A1 in Northumberland: Morpeth to Ellingham

Scheme Number: TR010059

7.25 Applicant's Comments on Responses to Further Written Questions

**Applicant's Comments on Responses to Further
Written Questions**

Revision: P02

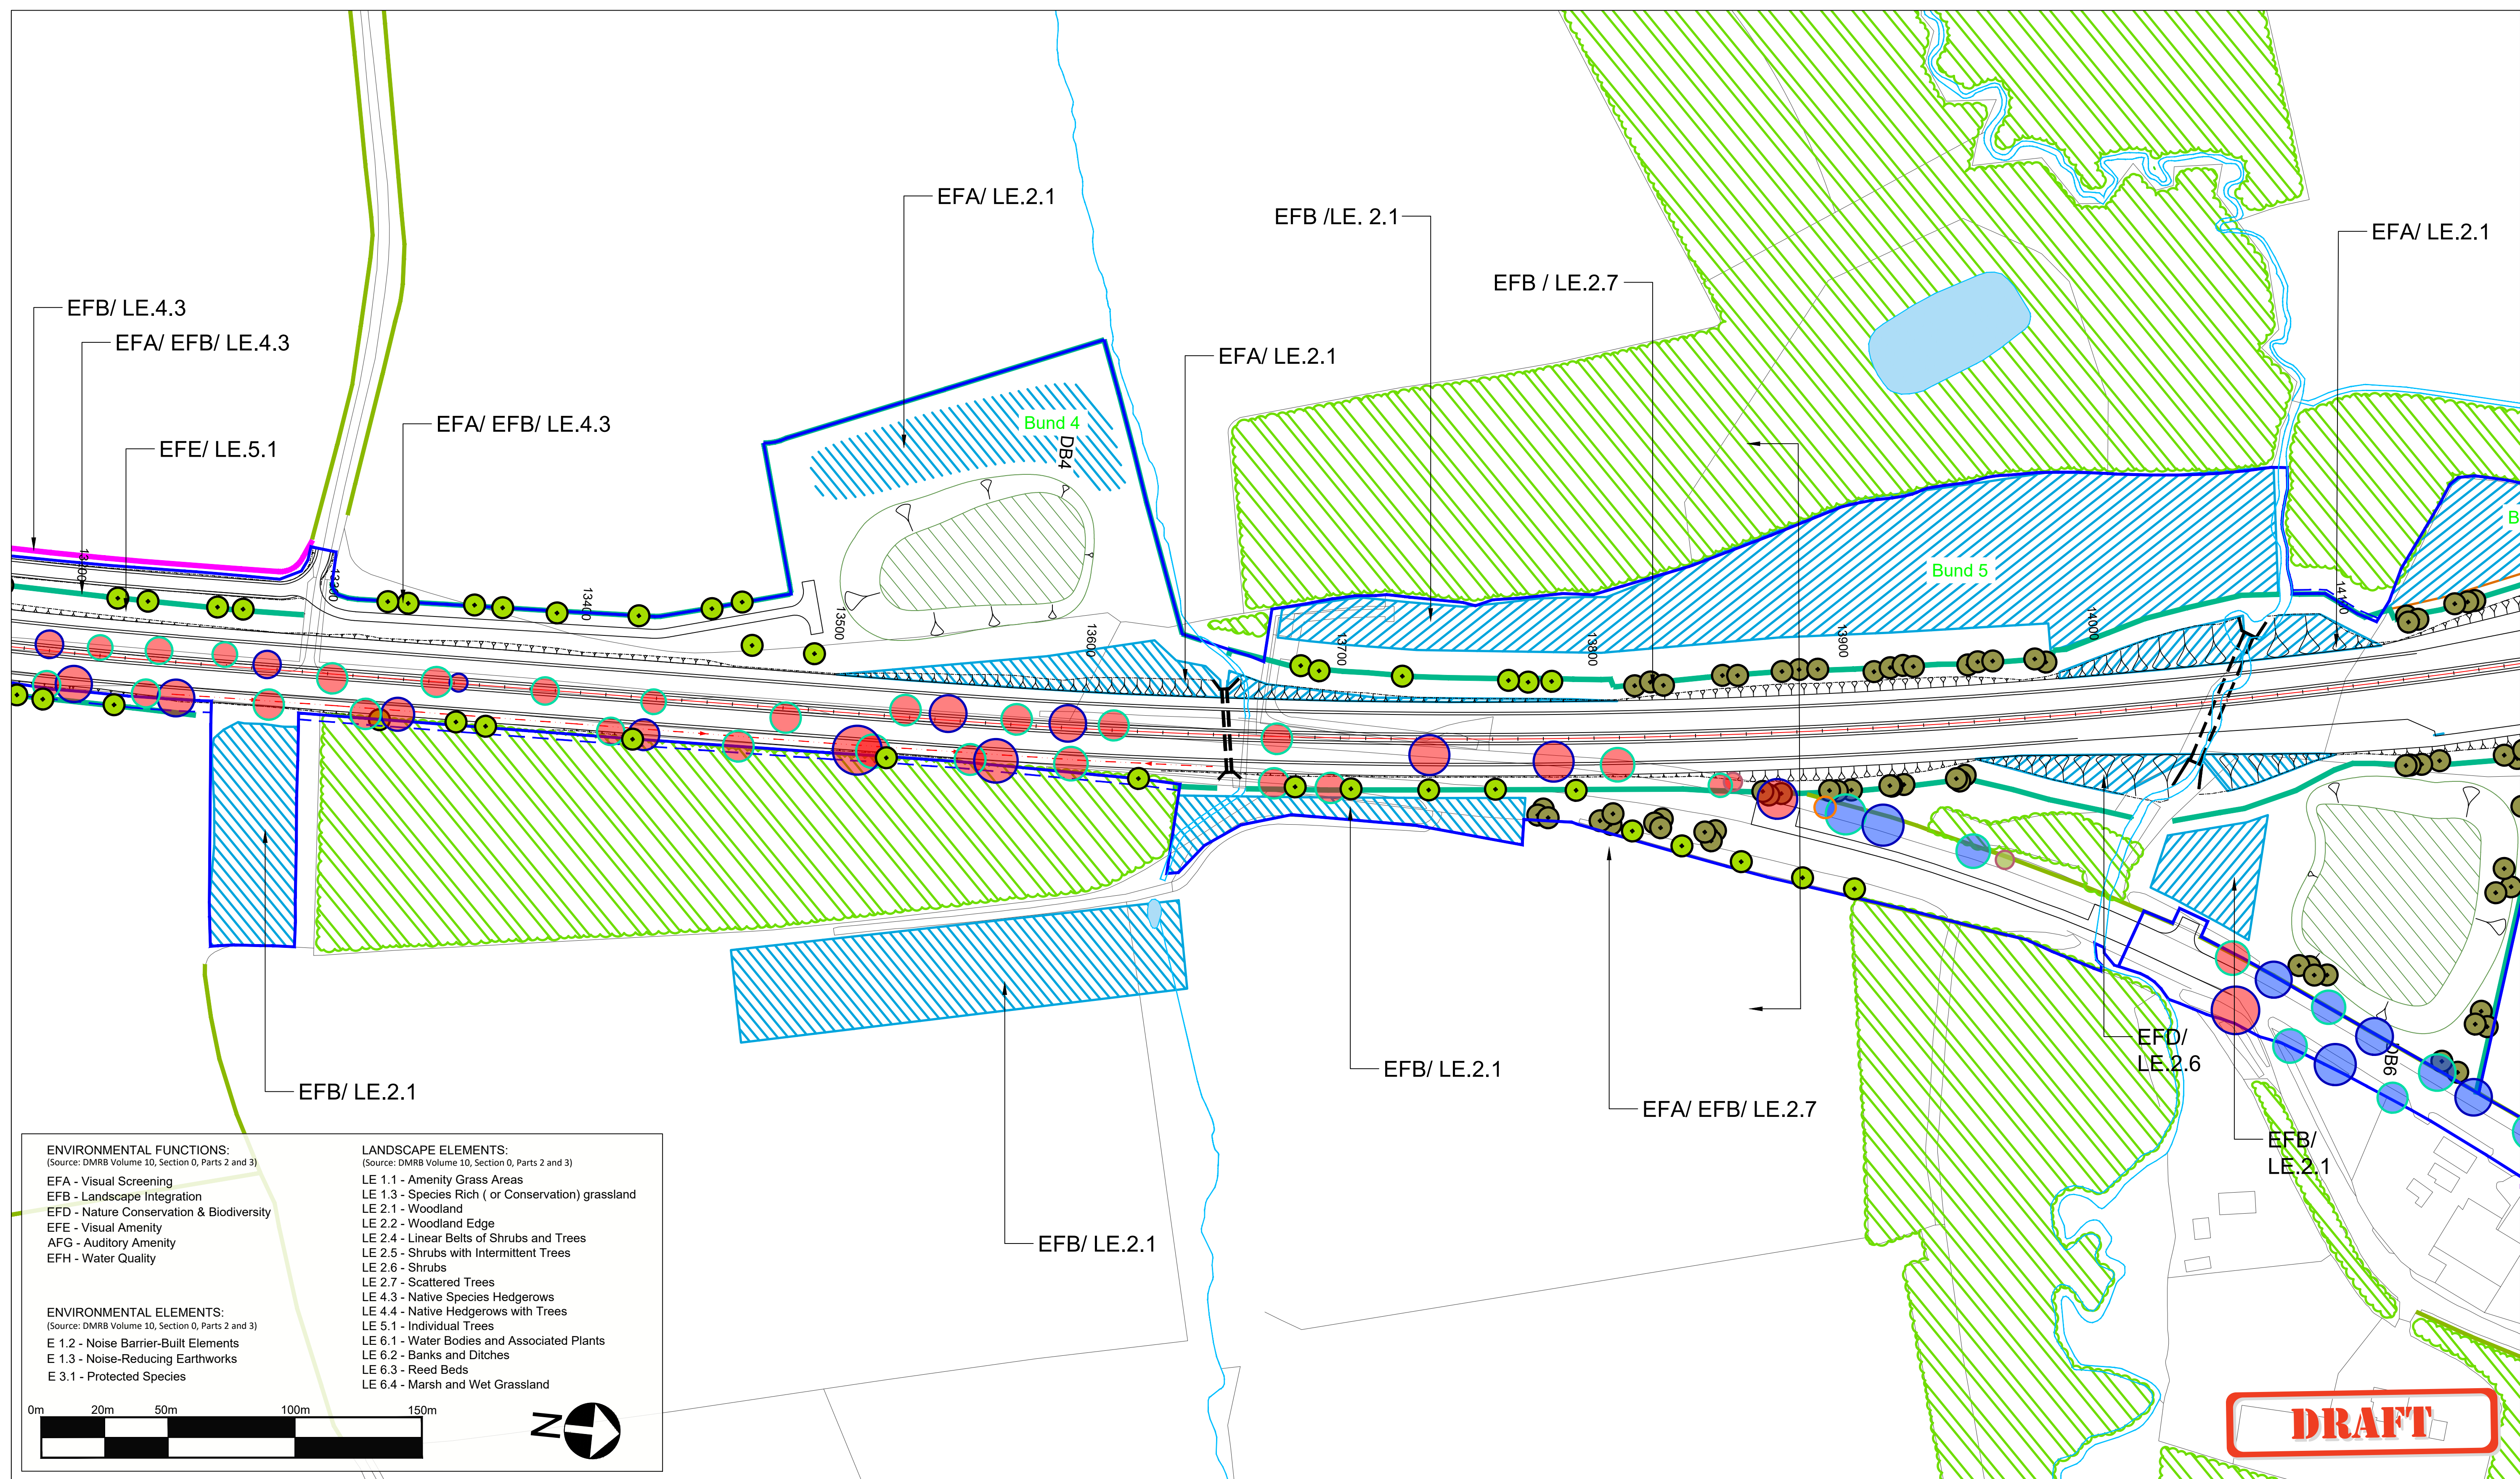
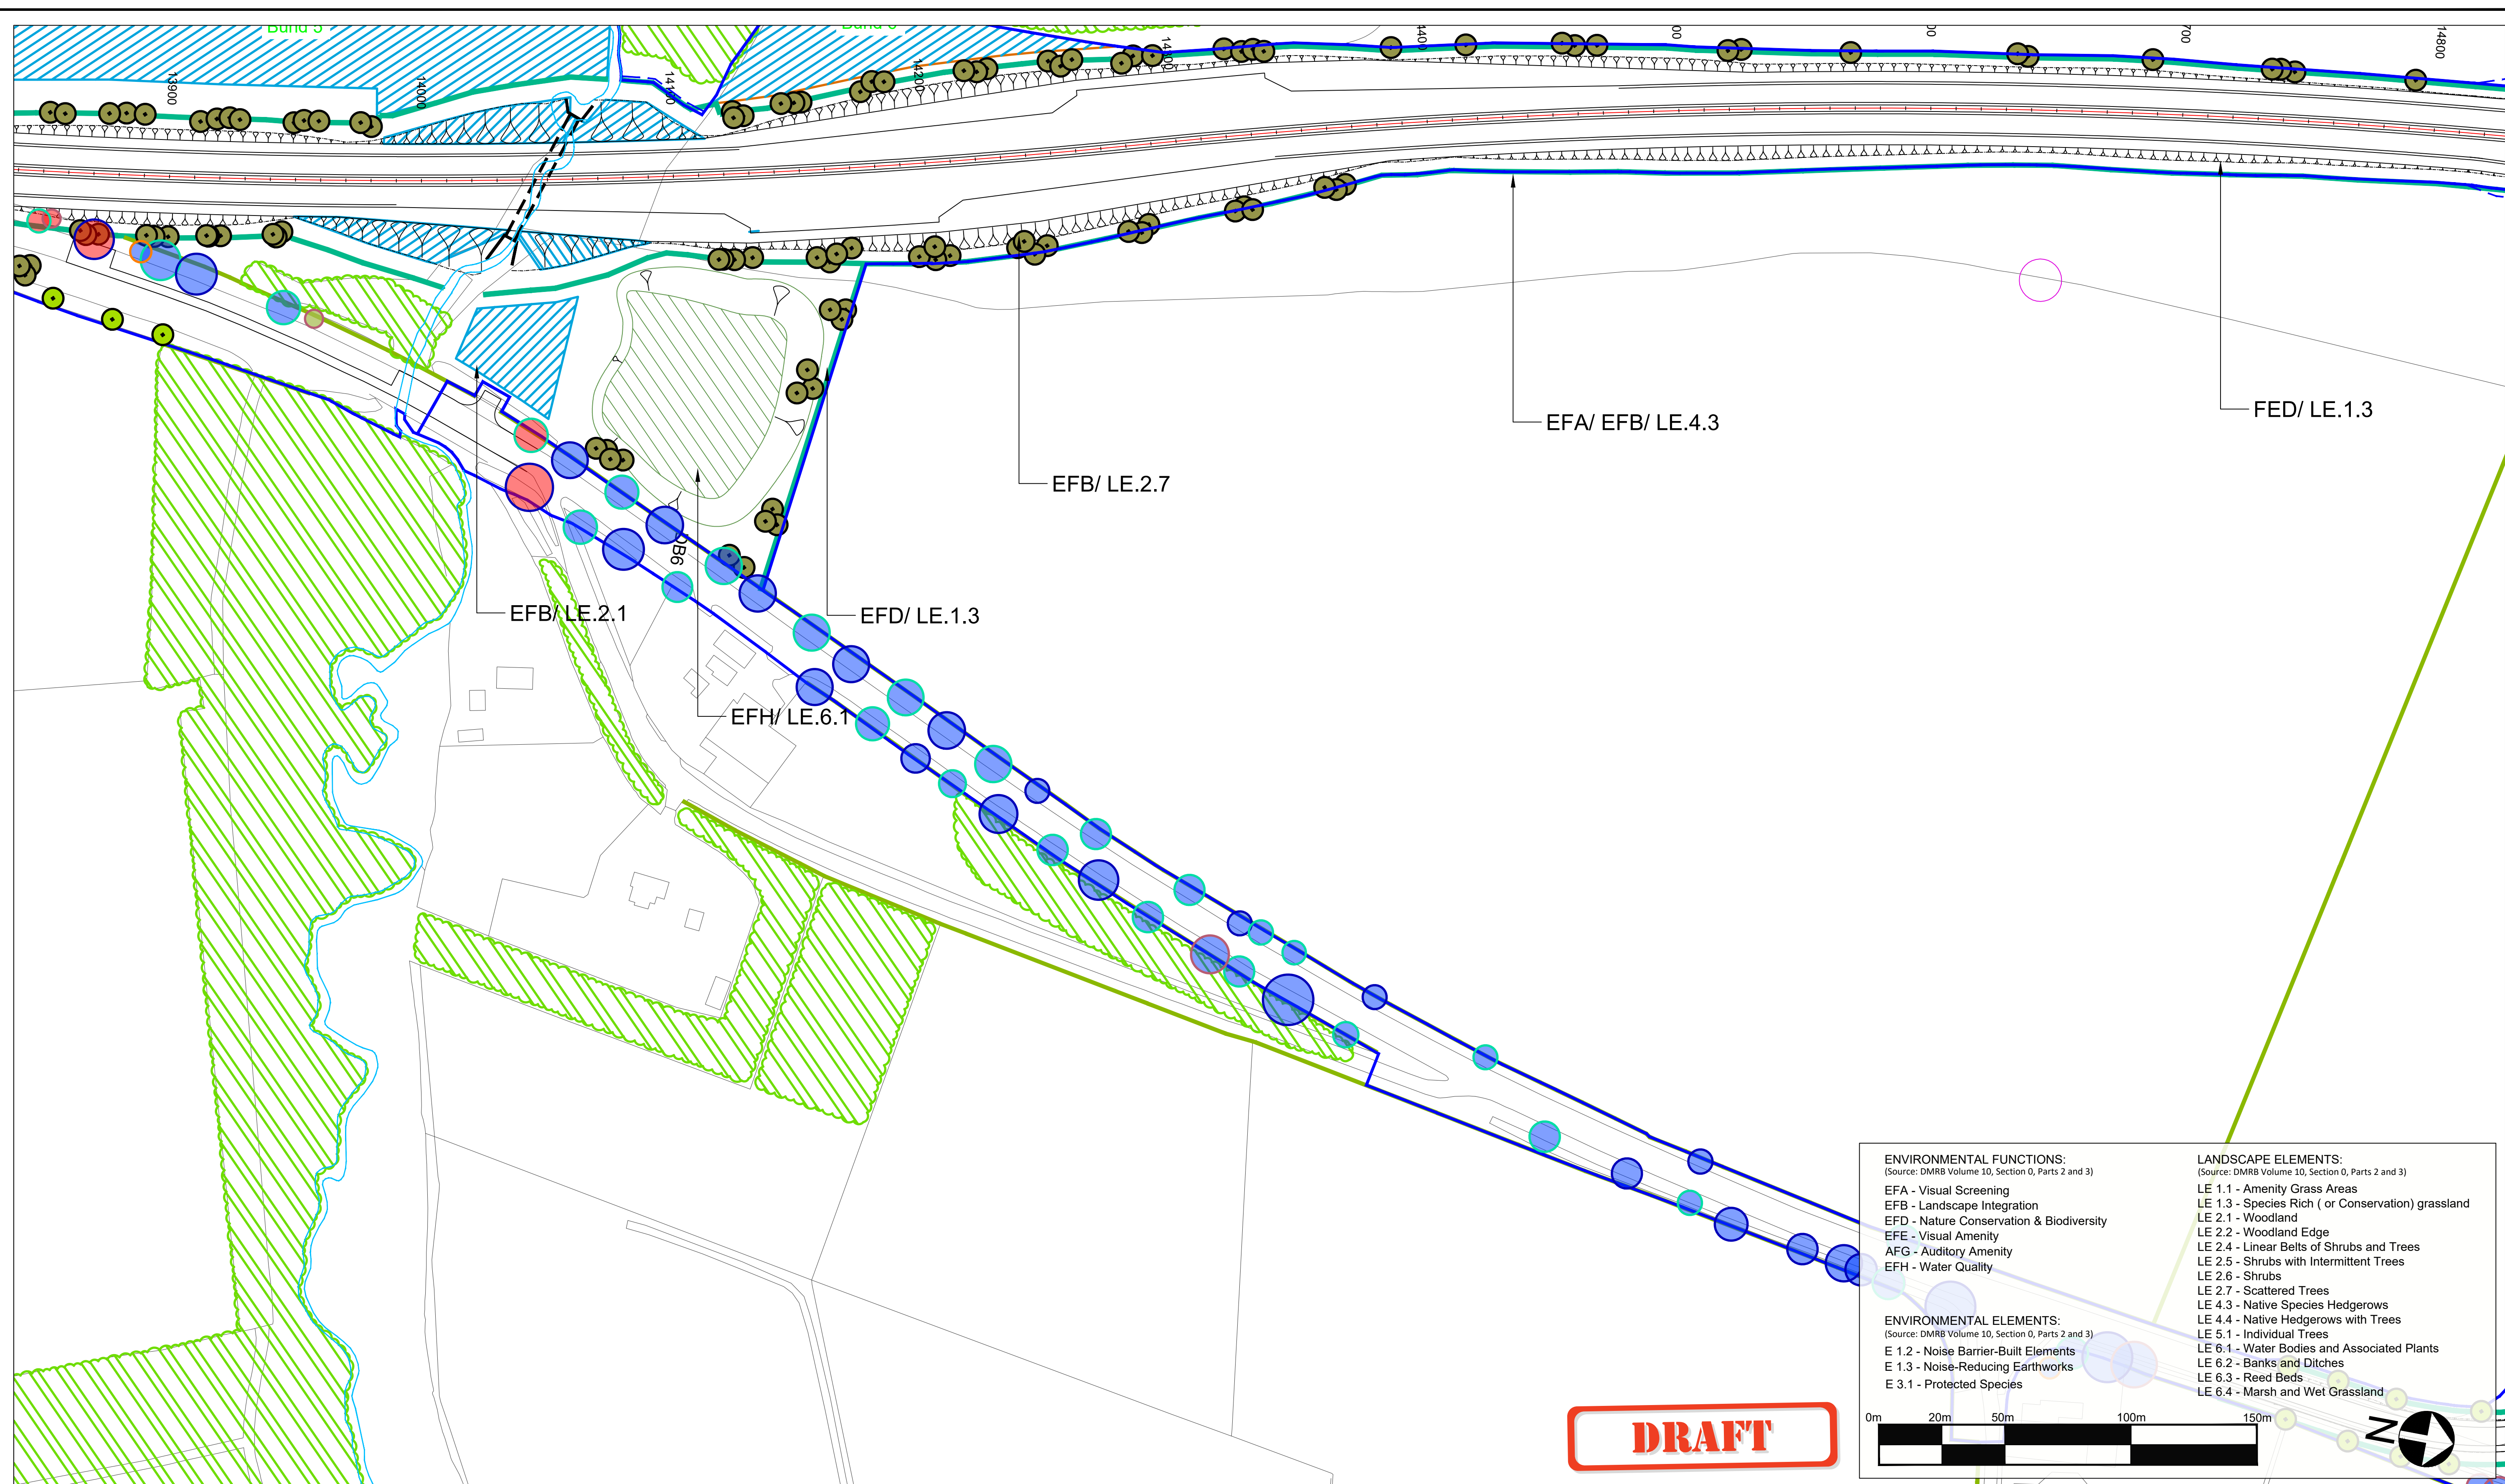
Ref. No.	Question to	Question	Interested Party's Response	Applicant's Response
LV.2.2 1.	Applicant IPs	The plans which form Appendix LV.2 Trees to be Removed and Replaced at Coronation Avenue WQ LV.1.8 [REP1-044] are annotated 'Draft'. The Applicant is asked to explain how this relates to the requirement in R5(3) of the dDCO for the landscaping scheme to include a strategy for the replacement of trees which are to be removed at Coronation Avenue? IPs are asked to comment on the proposals for Coronation Avenue.	In reviewing this documentation again, I remain disappointed by the scale of tree loss inflicted by the scheme. Undoubtedly the biggest impact is on the distinguished Coronation Avenue of trees which line both sides of the single carriageway. I am not aware of any other A classed road in the country which can boast such an extensive configuration of mature trees, which are now approaching 70 years age. The main source of frustration stems from an underlying belief that more could have been done to protect the trees and improve the levels of mitigation. For example, most of the work carried out on the existing road is asymmetric which means that the	<p>1. The removal of the trees at Coronation Avenue is necessary in order to construct the Scheme, either through direct loss of the trees or impacts on their roots that in the long term would reduce their viability. The removal of vegetation would be avoided where possible to safeguard any remaining trees, including those that make up the Coronation Avenue. This is secured through item SL-2 of Table 3-1 - Register of Environmental Actions and Commitments: The Scheme in Outline CEMP [REP5-012 and 013] (and as updated at Deadline 6).</p>

2.			<p>In total it appears that circa 200 coronation trees are to be felled and replaced with young trees which I understand will take a minimum of 15 years to mature. Even then the visual impact and environmental contribution will remain well short of what we enjoy today.</p>	<ol style="list-style-type: none"> 1. The Scheme would require the removal of existing roadside hedgerows and removal of 187no. existing trees that form the Coronation Avenue of trees. 2. The replacement of trees would be undertaken using advanced nursery stock, and this is secured through item SL-4 of Table 3-1 - Register of Environmental Actions and Commitments: The Scheme in Outline CEMP [REP5-012 and 013] (and as updated at Deadline 6). What this means in practice is that the trees would be of larger size when planted, being a minimum of 3m in height. The final height of the tree will depend upon the species selected. 3. It should be noted that trees will establish and grow continually until they reach maturity. The reference to 15 years is taken from the guidance for landscape and visual assessment, DMRB 135/10, a link to which is provided within Applicant's Responses to the ExA's Further Written Questions - Appendix C - Former and Updated DMRB Guidance [REP5-026]. This requires the assessor to consider the impact of the Scheme in the summer of year 15, when it is assumed that for the most part the planting will have sufficiently established in order to fulfil its function as mitigation. Trees, including those planted to replace the Coronation Avenue will continue to mature up to and beyond year 15. However, in the meantime

3.			<p>In looking at the plans for the new arrangement of replacement trees the Avenue effect would appear to have been lost. The configuration of the trees is no longer linear and there are too many gaps in the flow to emulate the Avenue effect. Furthermore, the distances between the trees flanking each side of the road are over 50 metres in some cases.</p>	<p>1. The strategy for the replacement of the Coronation Avenue, as agreed with NCC, is shown on Landscape Mitigation Masterplan Part A for Change Request Rev 3 [REP4-060], and secured through item S-L2 (c) of Table 3.1 – Register of Environmental Actions and Commitments: The Scheme in the Outline CEMP [REP5-012 and 013] (and as updated at Deadline 6). The strategy for the replacement of the trees that contribute to the Coronation Avenue would be on a like for like basis in terms of numbers and would replace the important landscape feature that would be impacted by Part A with an informal avenue effect, rather than 'pairs' of opposing trees, and which would be similar to what is currently experienced. This is identified in paragraph 7.9.14 (a) of Chapter 7: Landscape and Visual Part A [APP-044]. The replacement trees would also comprise more advanced nursery stock (and would therefore be larger and more discernible than transplants, which would make up the bulk of the mass planting of woodland and scattered trees), this is identified in paragraph 7.9.14 (h) of Chapter 7: Landscape and Visual Part A [APP-044].</p> <p>2. The replacement planting along the wider corridor would increase the width between the lines of trees either side of the Scheme. However, the replacement strategy is such that, over time, the tree lined nature</p>

Ref. No.	Question to	Question	Interested Party's Response	Applicant's Response
				<p>of the corridor would be substantially restored to form an informal avenue that would be a key feature of the view travelling along the A1, similar to what is experienced currently. The replacement strategy is identified on Landscape Mitigation Masterplan Part A for Change Request Rev 3 [REP4-060] submitted at Deadline 4, and secured through item S-L2 (c) of Table 3.1 – Register of Environmental Actions and Commitments: The Scheme in the Outline CEMP [REP5-012 and 013] (and as updated at Deadline 6). As such, the informal avenue effect would over time be restored.</p>
LV.2.6 1.		Appendix LV3 Response to LV.1.13 [REP1-051] considers potential additional mitigation measures, their suitability and the prospect of potentially reducing significant effects to non-significant. What are the views of IPs in respect of these further potential mitigation measures?	Although the opening paragraph does make the claim that additional mitigation may reduce significant effects to non-significant, I could not find any example in the rest of the document which suggested that this had been achieved.	<ol style="list-style-type: none"> 1. Within Appendix LV3 Response to LV.1.13 [REP1-051] consideration was given as to whether additional mitigation might reduce significant effects to non-significant. The Applicant reviewed the mitigation strategy for those receptors where a significant effect was anticipated to remain following construction of the Scheme and considered whether the effect could be reduced should further measures be identified. The conclusion of that review for all locations assessed was that further screening, in the form of planting or fences, would not provide sufficient mitigation or might in themselves result in impacts on views and/or changes to landscape character. As such, further screening is not proposed as part of the Scheme.
